April 8, 2024

Subject: Review Comment Response  
Geologic Hazards Evaluation and  
Preliminary Geotechnical Investigation  
Crossroads North  
Marksheffel Road and State Highway 24  
El Paso County, Colorado  
Project No. CS18526.001-105

This letter presents our response to review comments regarding our Geologic Hazards Evaluation and Preliminary Geotechnical Investigation for Crossroads North, located in El Paso County, Colorado. The following discussion provides specific items from comments and our responses.

SOILS & GEOLOGY CONDITIONS, CONSTRAINTS & HAZARDS NOTES**

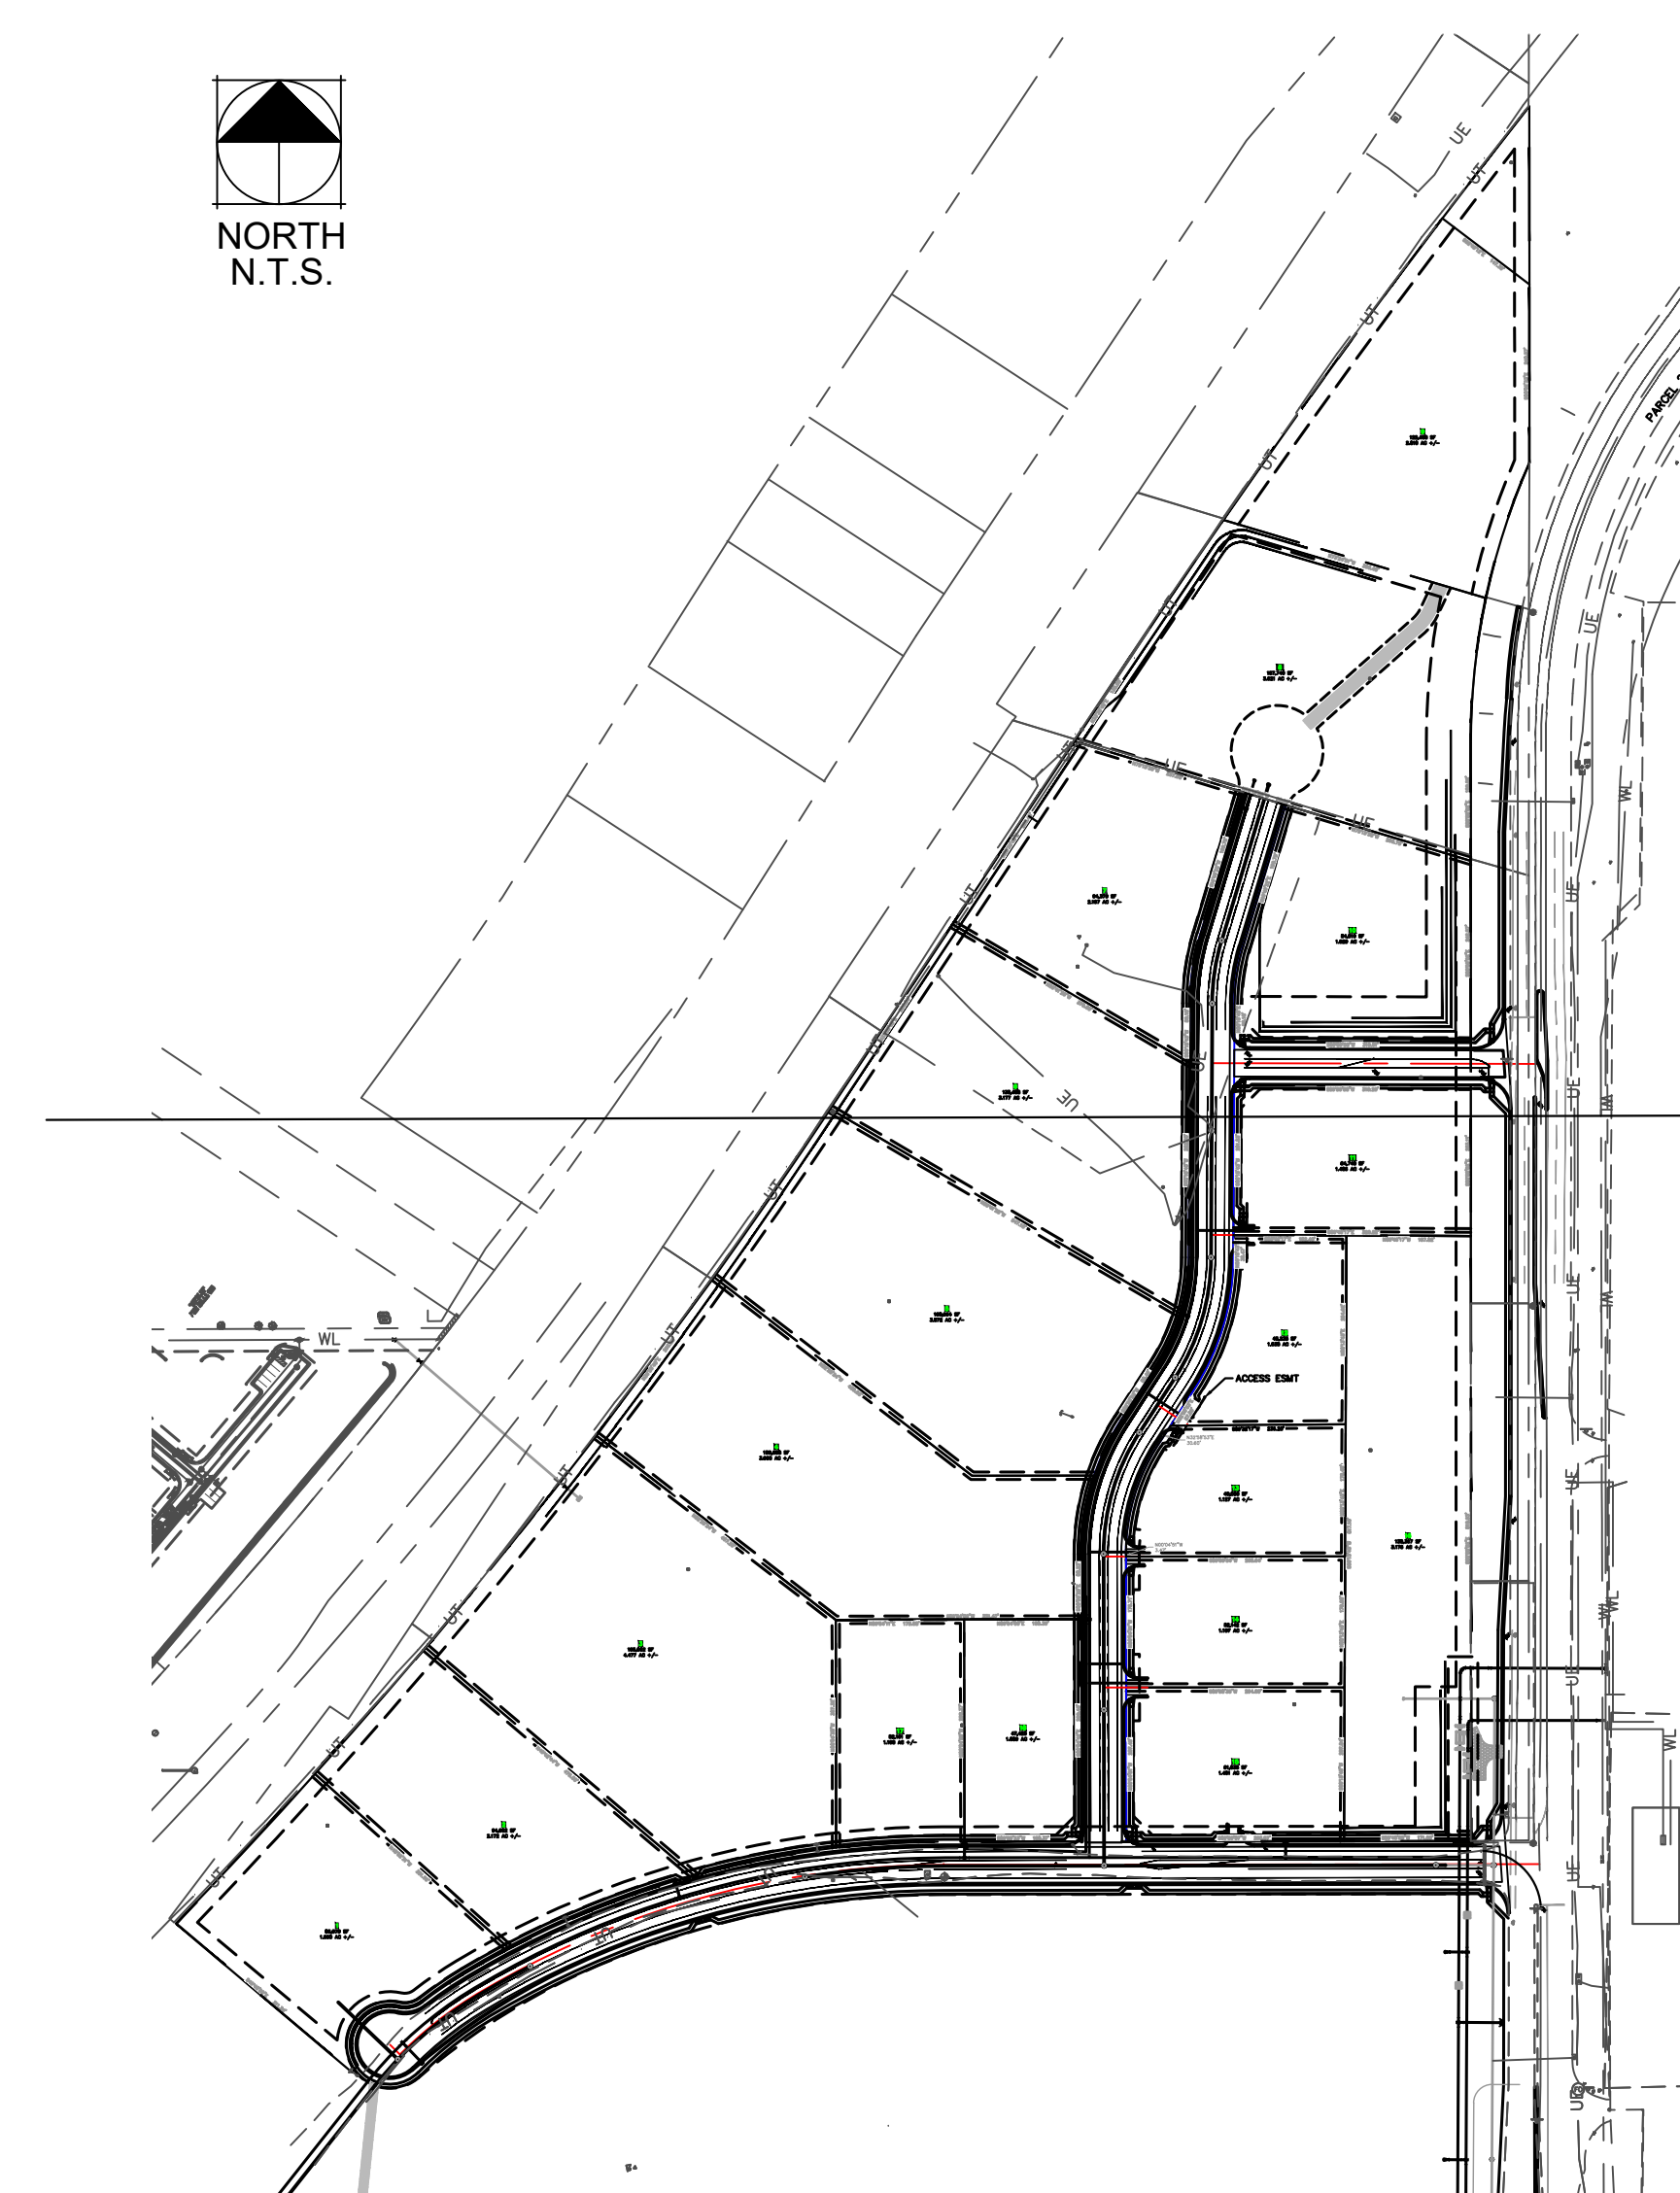
Review Comment, in green on cover sheet of Kimley Horn Preliminary Plan, print date January 10, 2024:

“Previous comments have not been addressed regarding soils & geology notes.”

“These geologic constraints also need to be depicted on the plan.”

“Update this note to the standard format for Soil and Geology Conditions...”

These comments appear to be regarding the Soils & Geology Conditions, Constraints & Hazards Note 2, which reads:

The information in the second paragraph of Note 2 accurately reflects the Geologic Hazards identified in the Geologic Hazards Evaluation and Preliminary Geotechnical Investigation (CTL|T Project No. CS18526.001-105, dated October 6, 2020). However, the information in the first paragraph is incorrect and was not contained in our report. We recommend removal of the information in the first paragraph of Note 2.

Existing fill stockpiles are mapped on Fig. 2 of the report and labeled as map unit “af”. Potentially hydro-compactive soils may be present anywhere within the development and cannot be mapped with any reasonable degree of accuracy. Attempting to map hydro-compactive soils within the site would falsely suggest the potential presence in some areas and not within other areas.

The standard formatting of Note 2 was provided, and a revision of Note 2 to comply with the standard formatting could look something like this:

The entirety of the proposed development may be impacted by geologic hazards. Mitigation measures and a map of the hazard area can be found in the report “Geologic Hazards Evaluation and Preliminary Geotechnical Investigation Crossroads North”, by CTL|Thompson, Inc., CTL|T Project No. CS18526.001-105, dated October 6, 2020), in file [NAME OF FILE AND FILE NUMBER] available at the El Paso County Planning and Community Development Department:

- Potentially hydro-compactive soils: may be present anywhere within the entire development. Site-specific, design-level geotechnical investigations performed for each planned structure should address the behavior of the on-site sands when wetted.
- Existing fill stockpiles: various locations shown on report Fig. 2 – Surficial Geologic Map, and labeled as map unit “af”.

**TIERED/TERRACED  
RETAINING WALL H<4'**

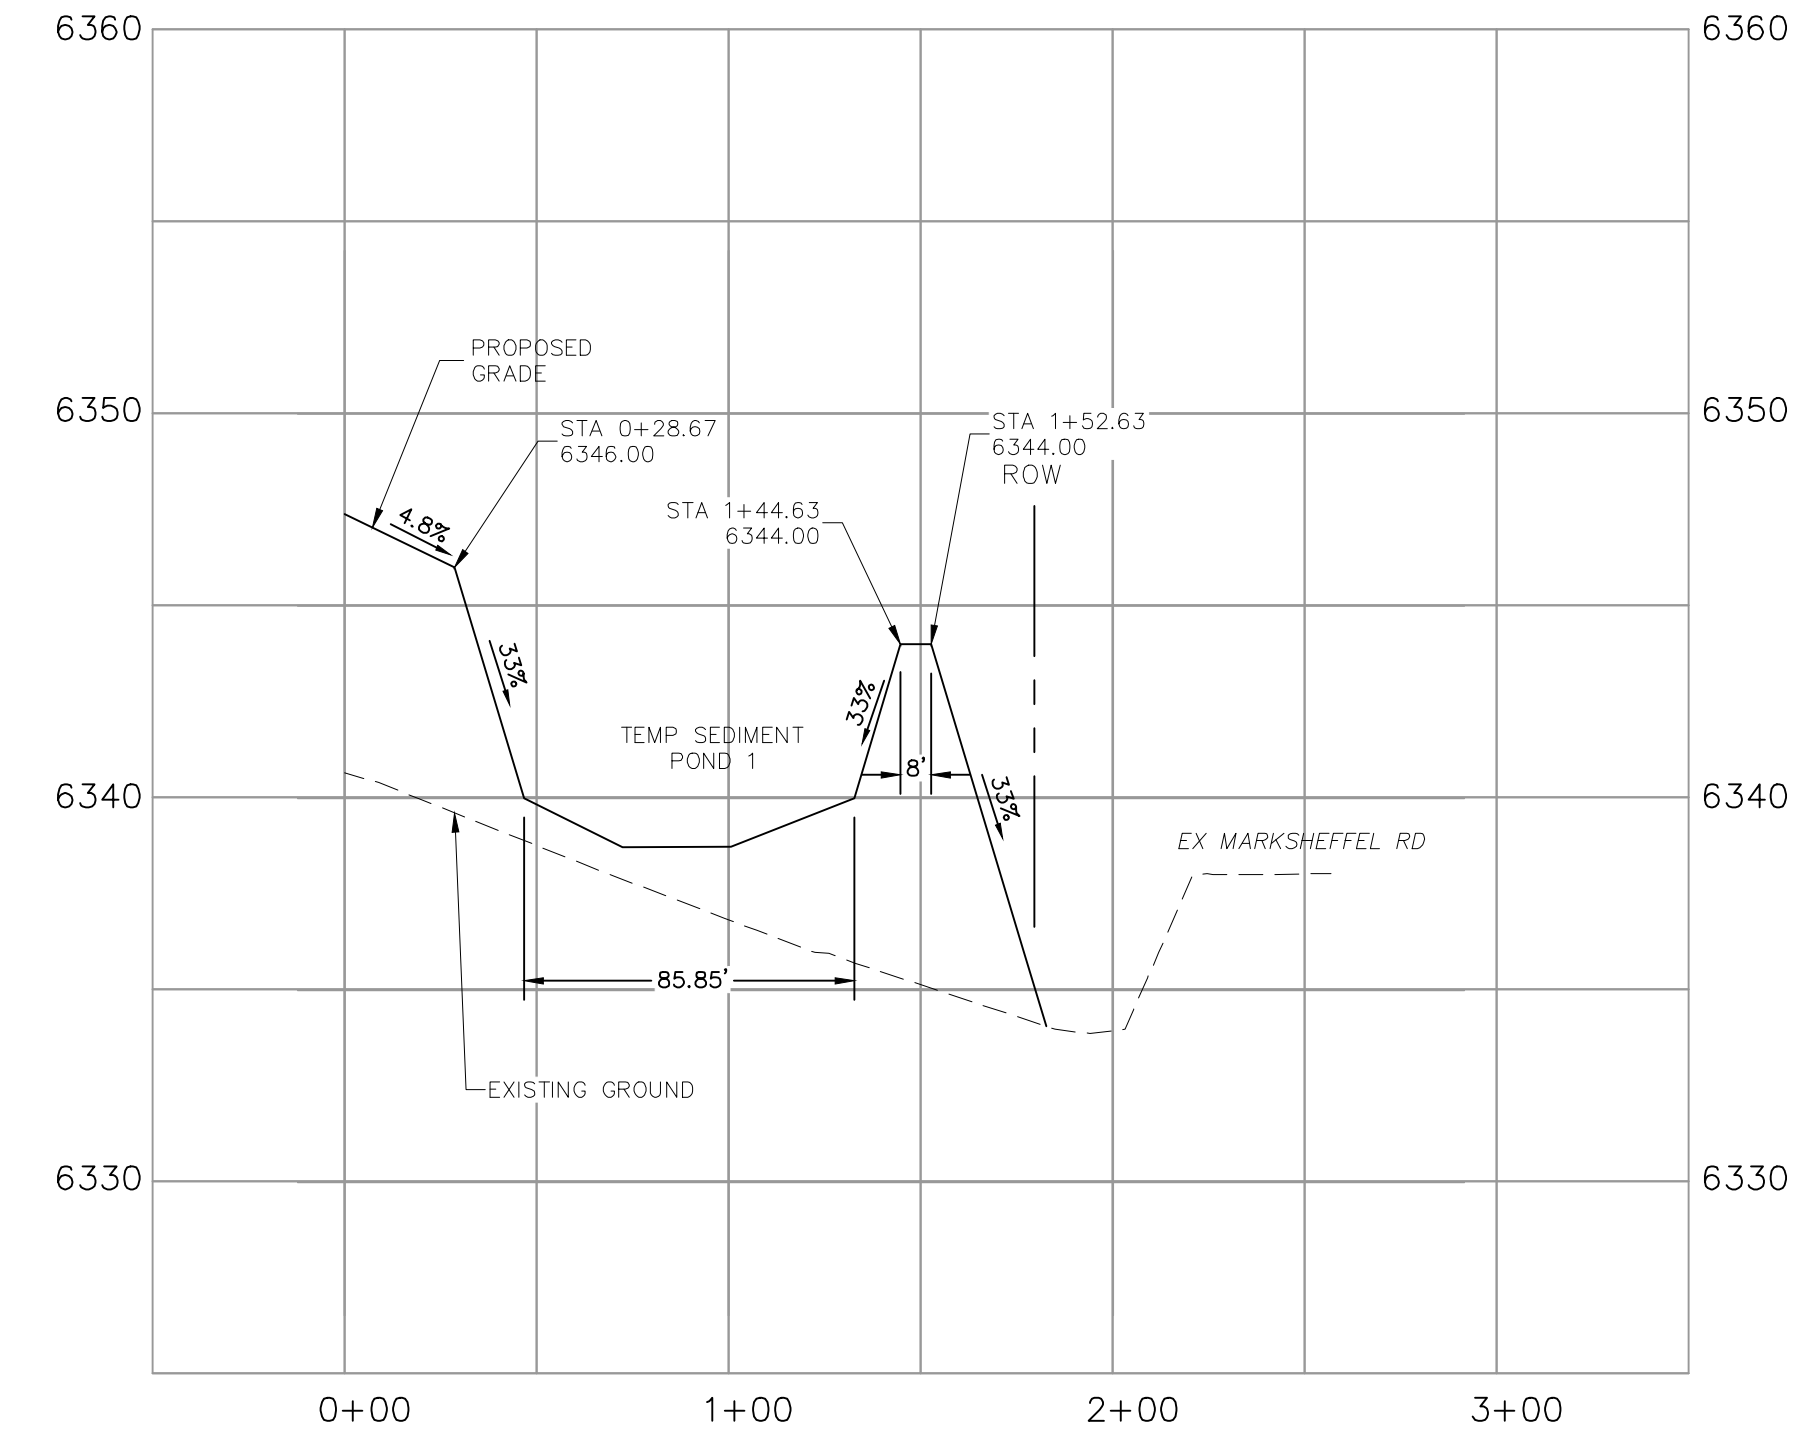
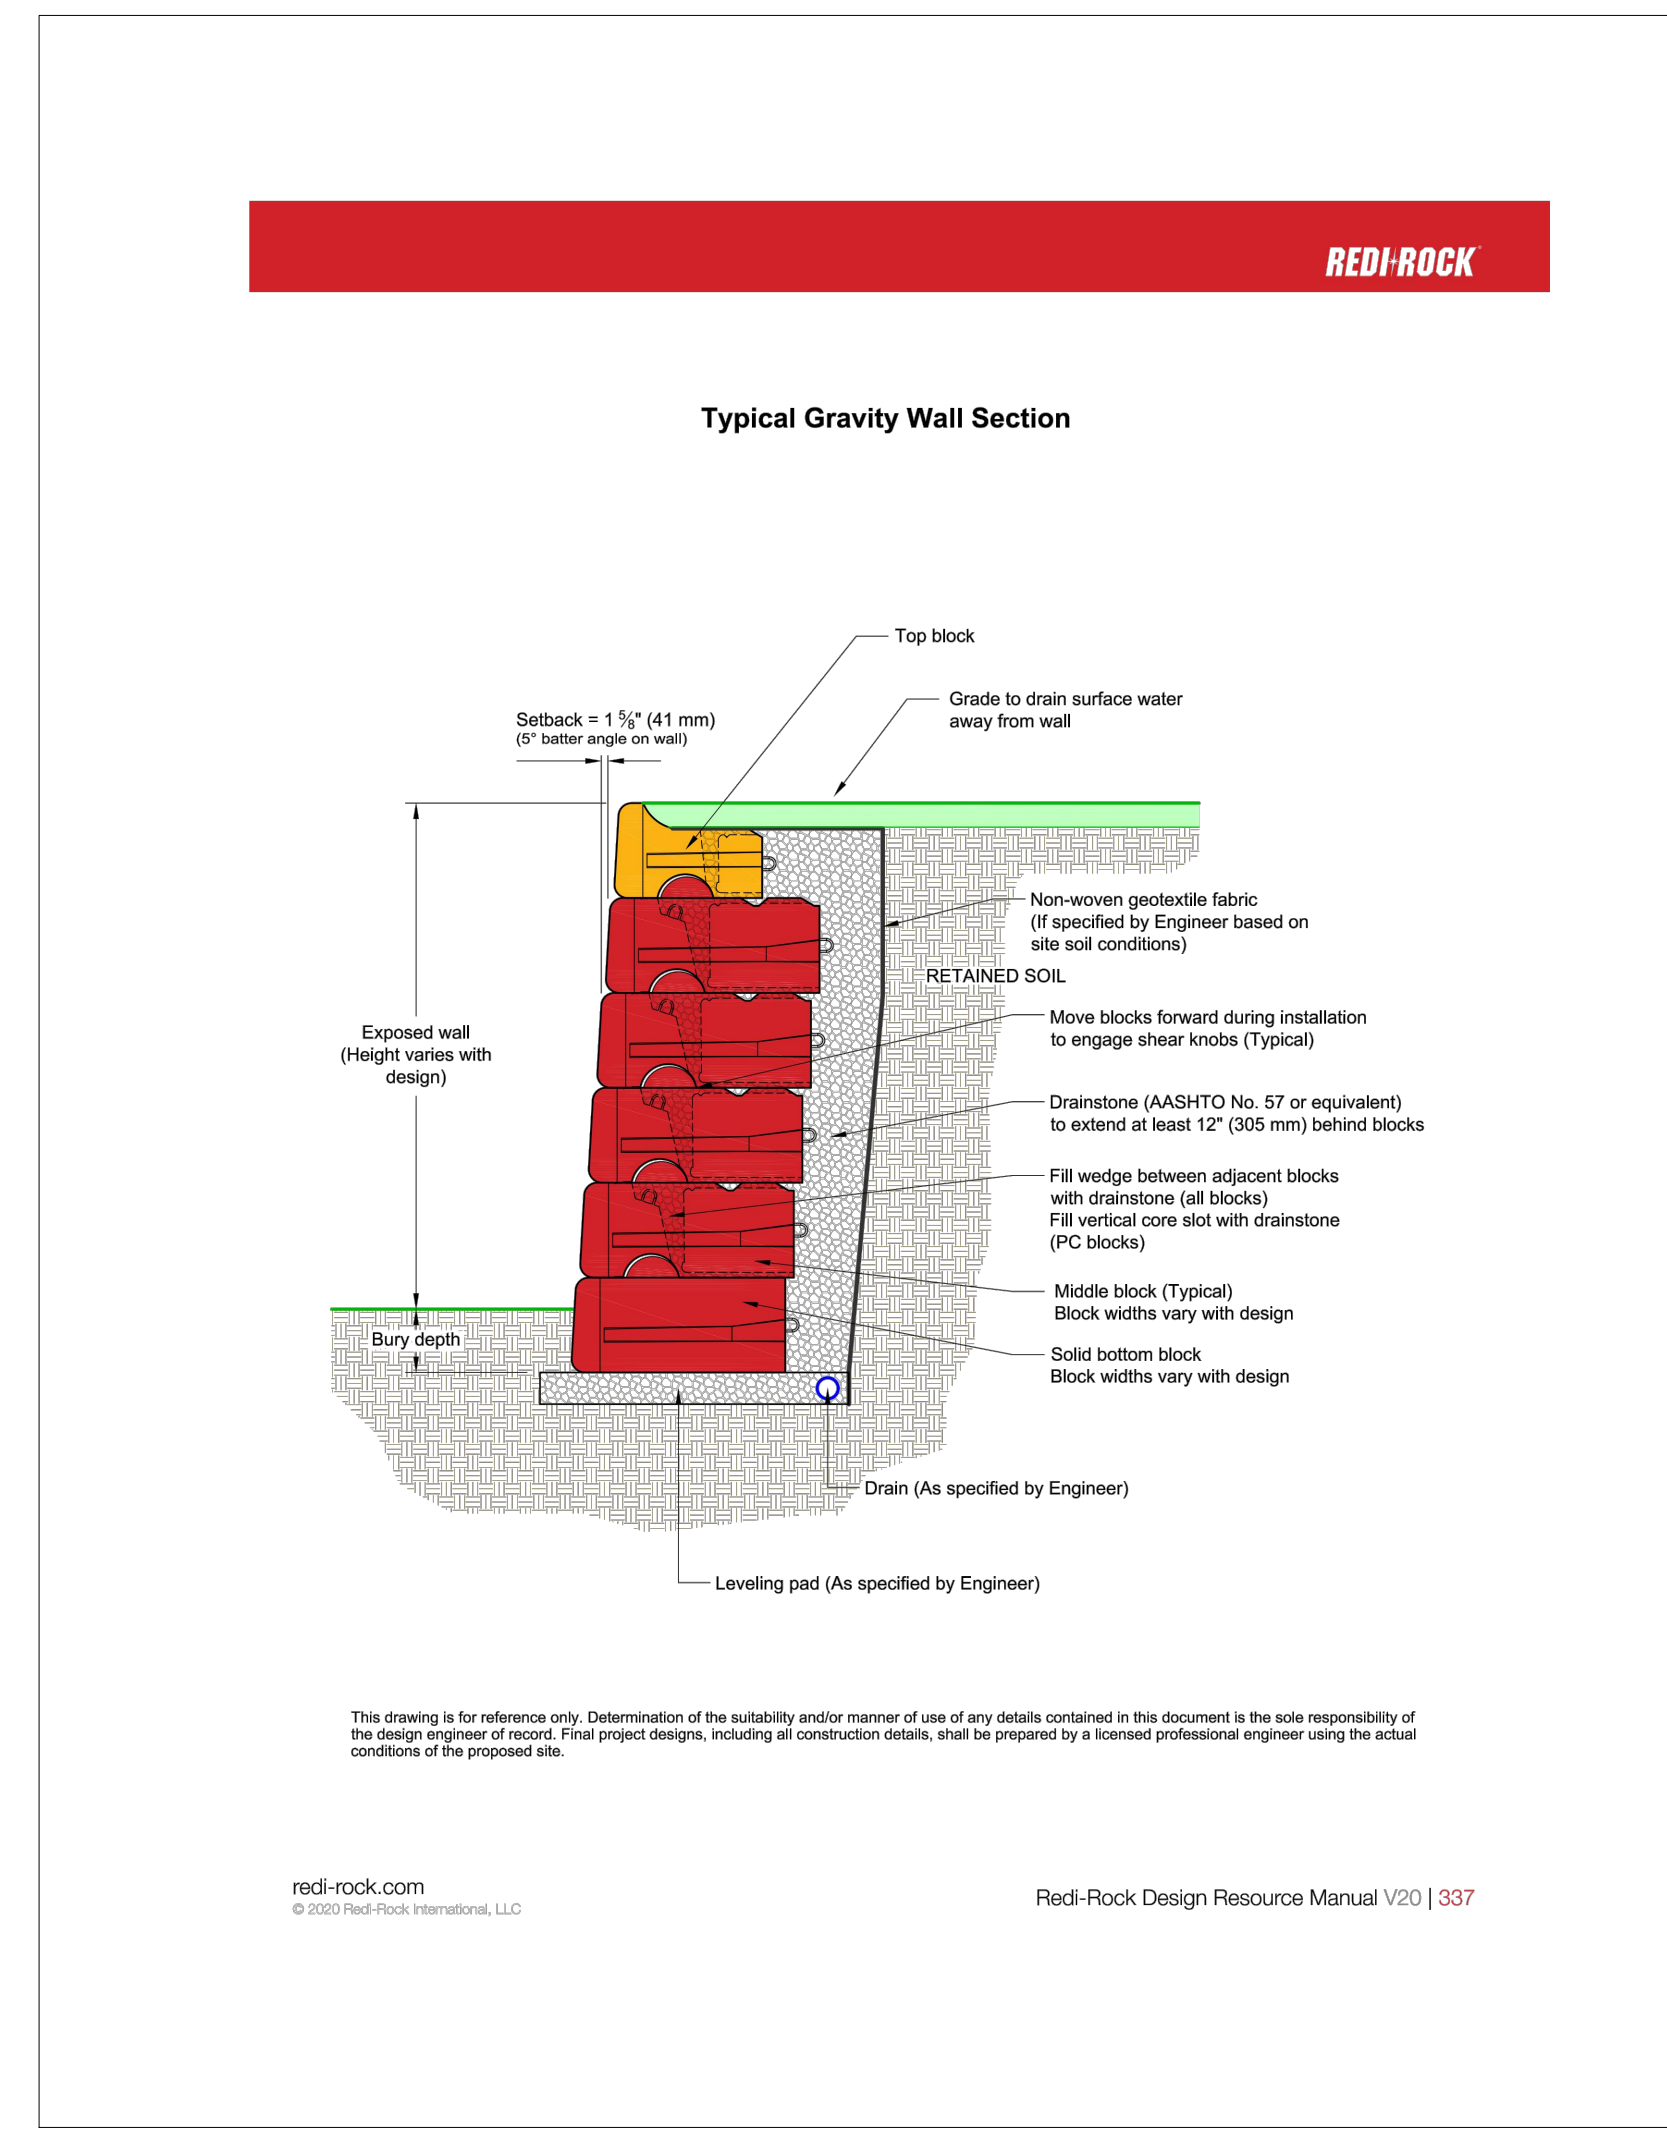
Review Comment in blue on Sheet 8 of 15 of the Crossroads North Early Grading and Erosion Control Plans, prepared by MS Civil Consultants, Inc., dated August 2023:

“Based on the offset between tiered walls the retaining wall design the design does not meet the two highlighted sections of the Pikes Peak Regional Building Code Section RBC105.2.1 and will require building permit through PPRBD.

Provide a reference to the retaining wall construction plans and submit a copy of the retaining plans to regional building for review and approval.

The early grading plans will not be approved until the retaining wall plans are approved.

Unresolved from review 3 and 4.”

We understand that there are retaining walls planned for the development and that some of the walls may be built during the first phase of early grading along Highway 24. The final design has not been developed and information on the number of walls, final location, size, or type of walls was unavailable. A typical gravity block retaining wall section is included on Sheet 8 of 15; however, this detail was provided by a wall manufacturer, not the project wall designer, and designs will vary based on height, surcharges, number of tiers, back slopes, and other factors.

Retaining walls should be designed in conformance with local codes. Retaining walls over 4 feet in exposed height, and retaining walls that are subjected to surcharge loading, such as that exerted by a tiered retaining wall system, should be designed by a professional engineer. Retaining walls designed by a professional engineer should include global stability analysis as part of their design. Part of the retaining wall design process should be a site specific, design-level geotechnical investigation, and should be provided as part of the future site development plan design.
